Angmering Parish Council
Mr Huskisson
5 Orchard Way
Fontwell
West Sussex
BN18 0SH

Your Ref:
Our Ref: A/158/08/
Please ask for:
Ms E E Hearsey

Erection of 11 dwellings with rear parking court & associated landscaping
Station Road Angmering

Proposed Site Layout @ 1:500

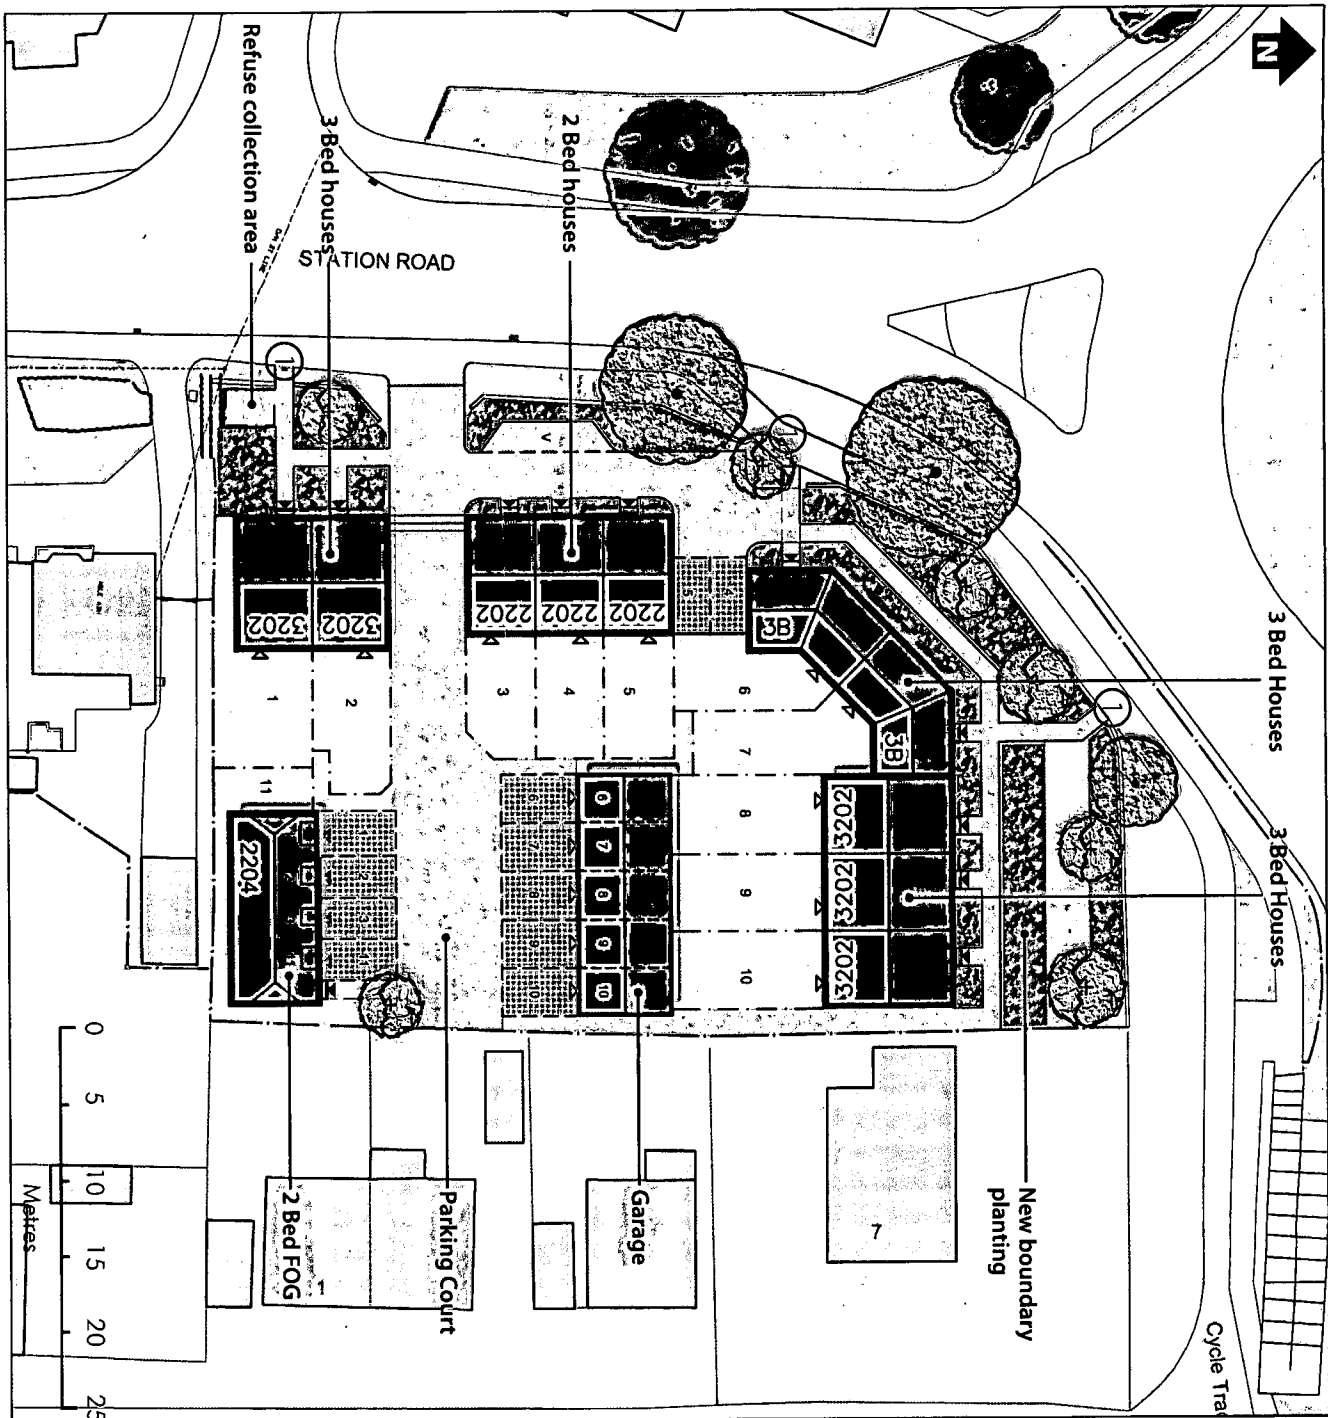
It was agreed that there was no objection in principle, however the Committee were disappointed to find that the number of dwellings proposed falls just short of a number that would provide statutory planning gain. The Committee would query whether the refuse area is adequate for eleven properties.
